**Observation on Strategic Housing Application by Cairn Homes Properties Limited:
Demolition of 'Winterbrook', and the former dwelling attached to Barrington Tower (a
protected structure), construction of 534 no. Build to Rent apartments, creche and
associated site works. Address of development: "Barrington Tower", Brennanstown Road,
Dublin 18. (ABP Ref. 313281)**

Observation on Strategic Housing Application by Cairn Homes Properties Limited:
Demolition of 'Winterbrook', and the former dwelling attached to Barrington Tower (a protected structure), construction of 534 no. Build to Rent apartments, creche and associated site works. Address of development: "Barrington Tower", Brennanstown Road, Dublin 18. (ABP Ref. 313281)

4 Proposed North Elevation - Block G
 1 : 200

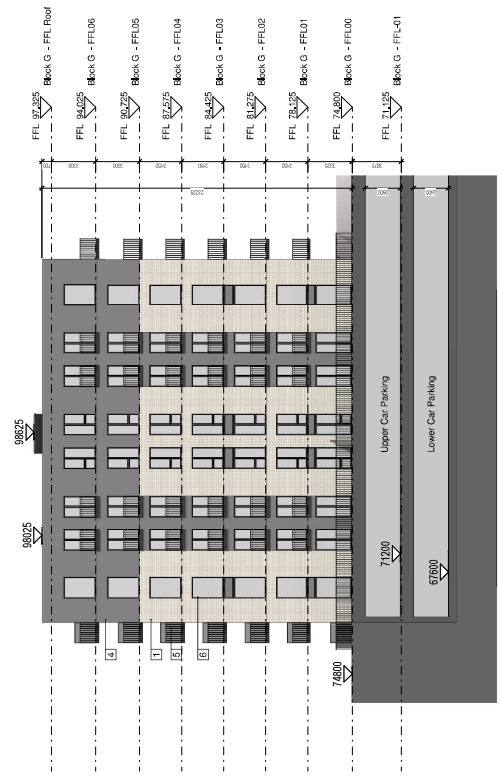
- I note (based on the Proposed Site Plan drawing) that Block G and H are located within c. 12 m of each other and include (from elevational drawings) what appear to be windows on the elevations that face each other. It is unclear from the elevational drawings, for example for the northern elevation of Block H (which contains windows) and the southern elevation Block G (which contains windows) if windows are to contain translucent glazing or how overlooking from windows will be properly mitigated. See also page 50 of the Architects Design Report which shows that there is a distance of less than 10m between Blocks I and J, and less than 10m between Block F and E where similar issues arise.
